# Building Code of Australia 2016

Report for BCA Compliance

PROJECT NAME: Sydney Opera House – Renewal Project – Concert Hall – for DA Submission

DATE: 7 September 2018

1 DETAIL PLAN - LIFT 29- LEVEL 3A & 4
A1208 1: 50

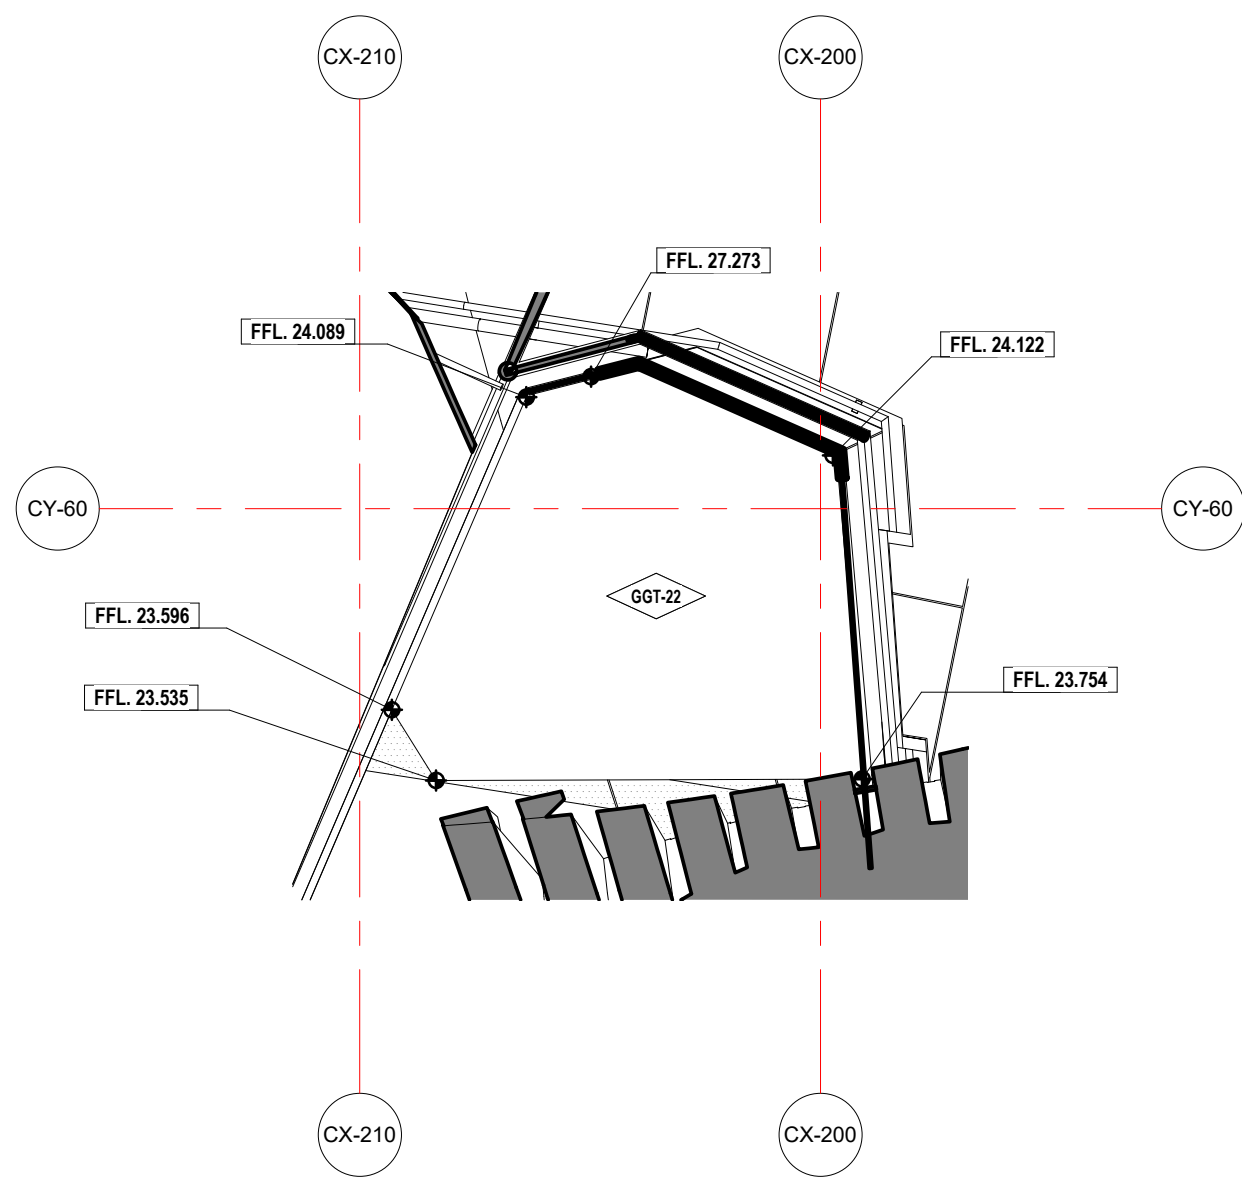
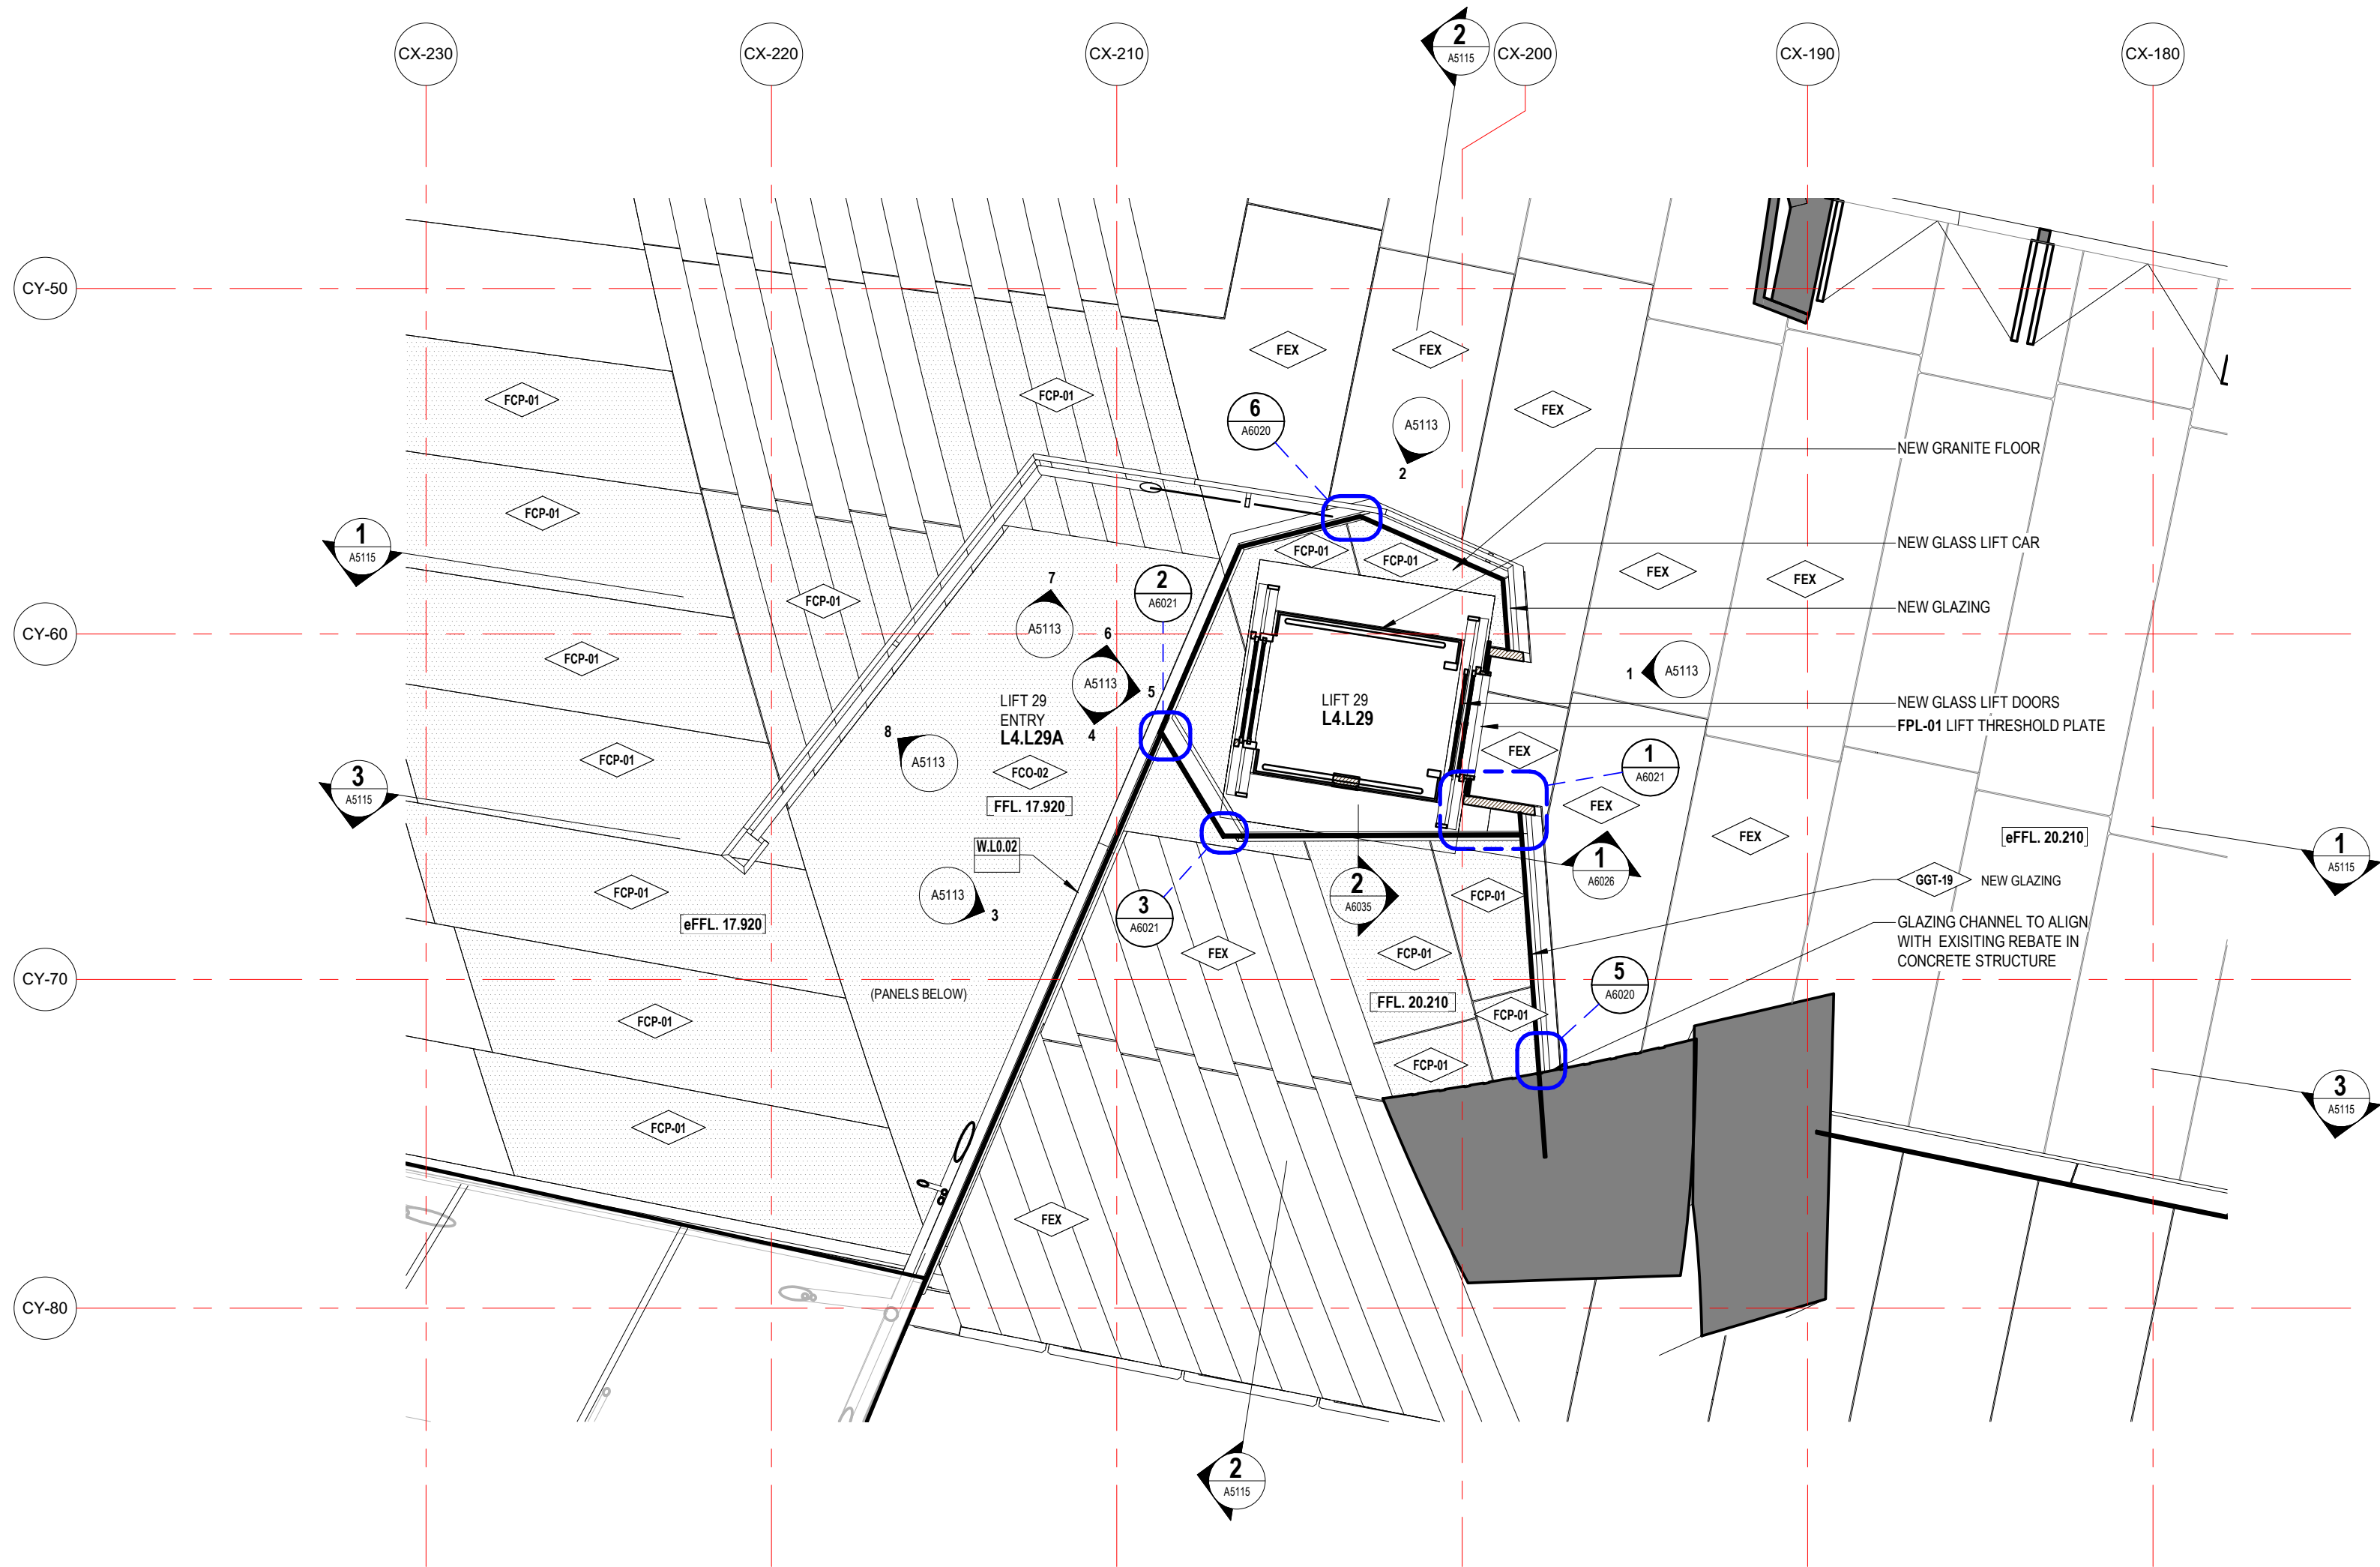
12	Northern Foyer Lifts 29 & 30 connect 3 storeys without the required fire isolated shaft protection.  Lift motor room not fire separated from the remainder of the building.	Fire Safety Engineer has confirmed the feasibility of a Performance Solution, refer Section 6.2 of Draft Fire Engineered Report for 100% Tender Documentation 243928-06 Rev A dated 22.11.2017	C1.1, C2.12, C2.10, C3.10	CP2
13	The plans illustrate a grouping or wheelchair seating spaces in excess of 5 spaces to the Stalls areas.	A justifiable Performance Solution is required from the Access Consultant in support.	D3.9	DP1
14	Orchestra Platform refurbishment is to include automated Forestage Lift. This appears to be a technical non-compliance with the BCA?	Vertical Transport Engineer and Access Consultant to confirm compliance or otherwise.	E3.6	DP1, EP3.4

26	Lift 29 & 30 – Inadequate level of BCA DTS fire rating to supporting members.	<p>Fire Safety Engineer has confirmed the feasibility of a Performance Solution.</p> <p>This issue does not appear to have been included in FER Performance Solution 6.2.</p>	C1.1	CP1
